**NOTICE OF DETERMINATION OF
DEVELOPMENT APPLICATION NO. 165.1/2019**
ENVIRONMENTAL PLANNING AND ASSESSMENT ACT, 1979

<i>Property Description:</i>	Lot 1 DP 515773, No. 2 Widemere Road, Wetherill Park.
<i>Description of Development:</i>	Proposed removal of trees, earthworks and the construction of an industrial building including the construction of an internal road and associated hardstand manoeuvring area, signage, drainage works and landscaping for the purpose of a drop-off Community Recycling Centre.
<i>Date of Determination:</i>	09 December 2019
<i>Date of Operation of Consent:</i>	10 December 2019
<i>Date Consent Will Lapse:</i>	10 December 2023

## 01 SITE PLAN

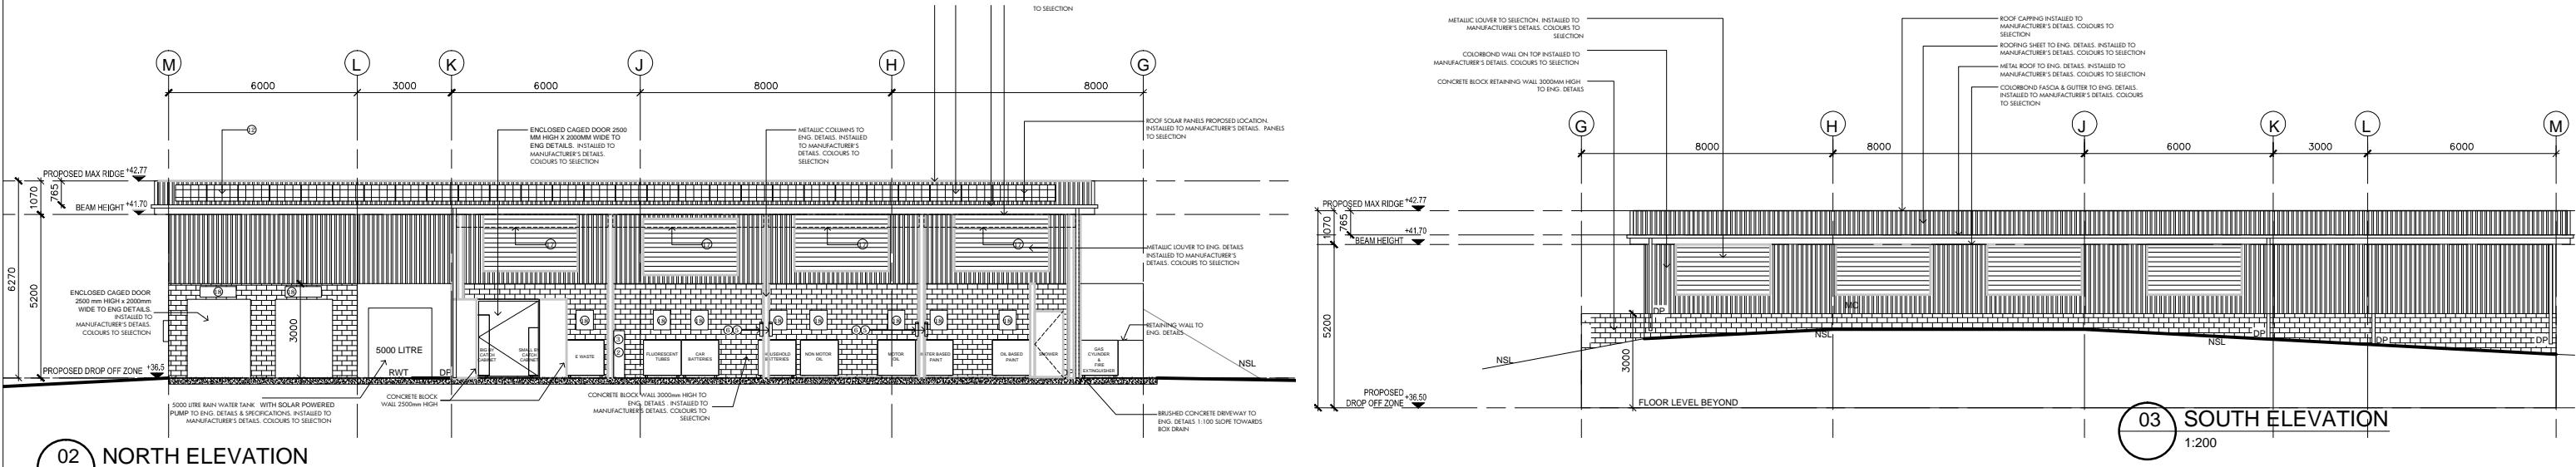
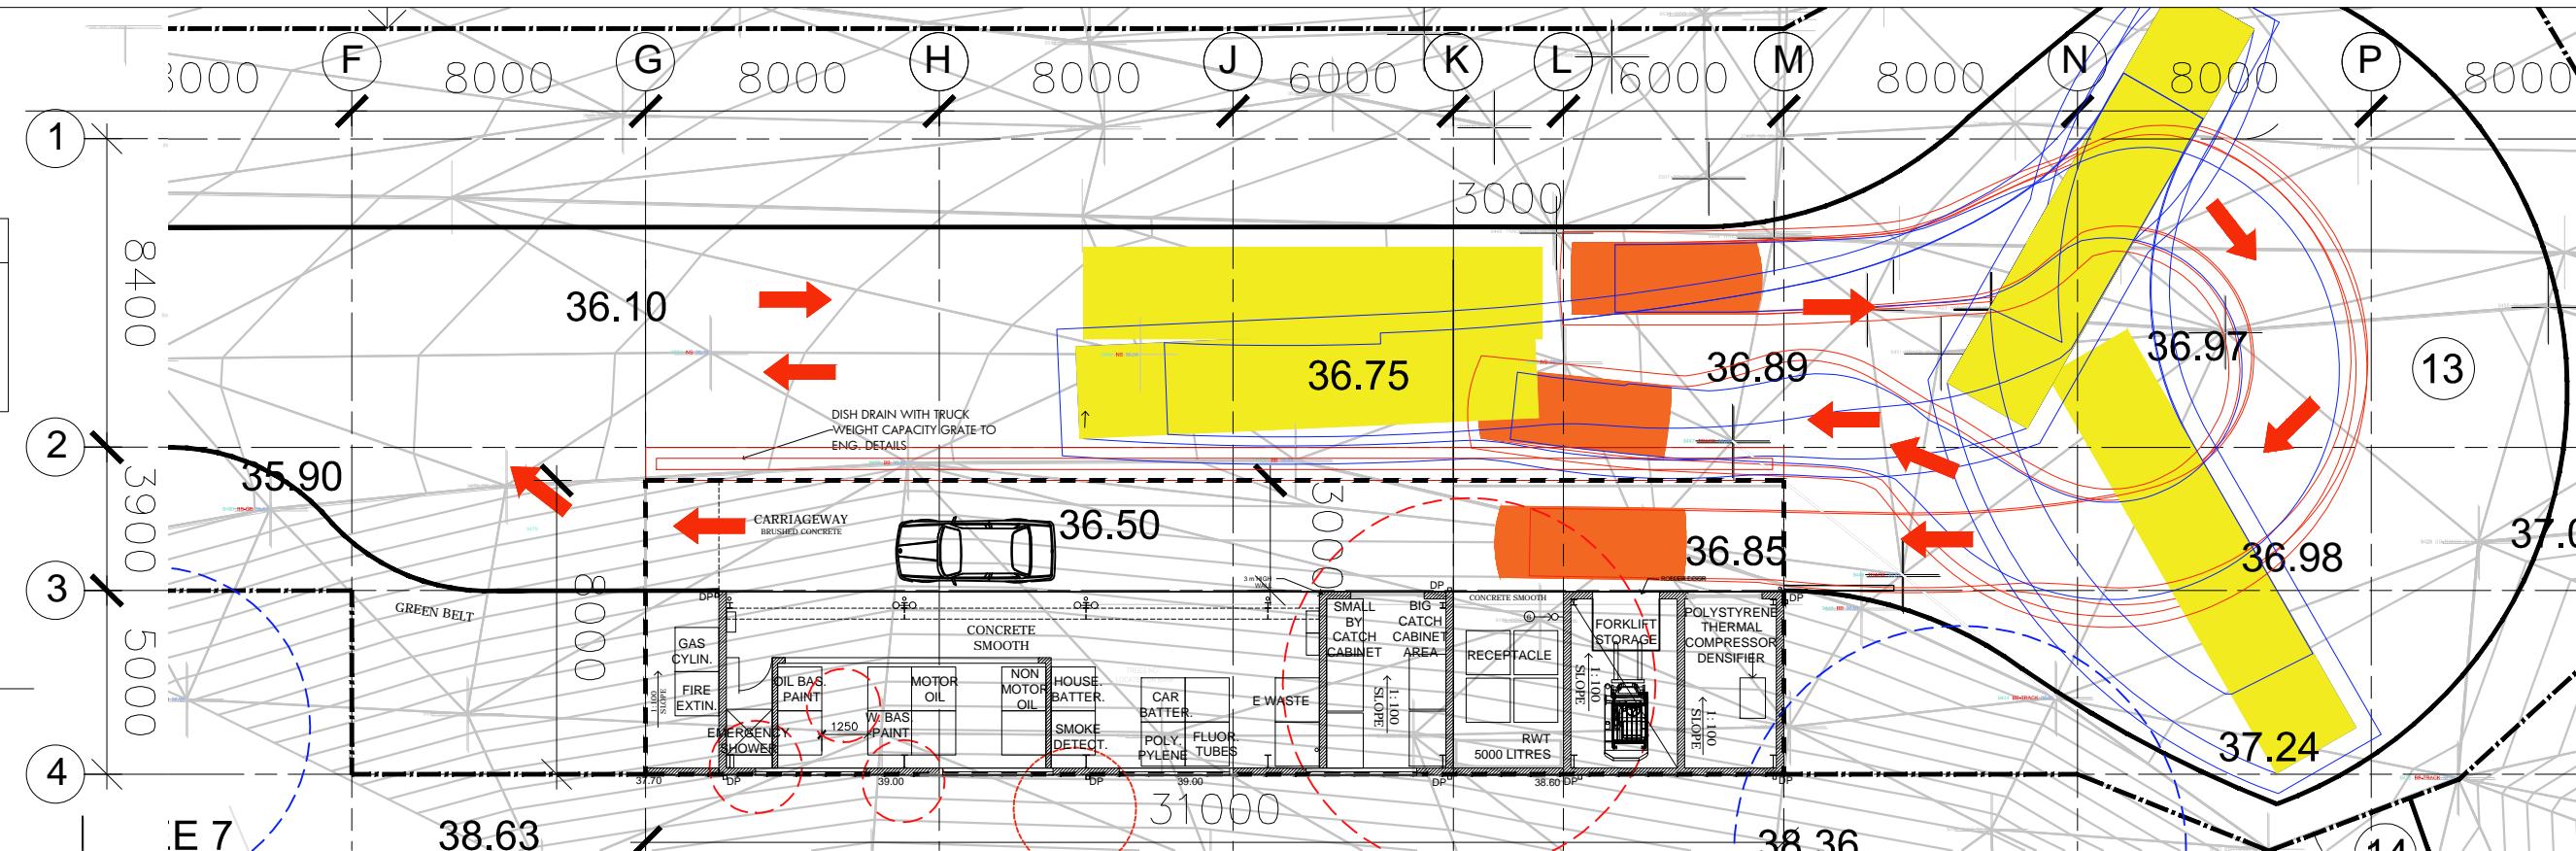
10. Updated Site Plan

Prior to the issue of a Construction Certificate, an updated Site plan, demonstrating the following, shall be submitted and approved by the Manager of Development Planning at Fairfield City Council:

- a. The proposed driveway width and the sight distance requirement for the access driveway shall comply with the requirement of AS 2890.2:2002.
- b. The proposed driveway profile (grades and level) shall comply with the requirements of AS 2890.2:2002.
- c. The entry point of the driveway shall be at least 1 metre clear of power poles, telephone poles, street trees and metre boxes.
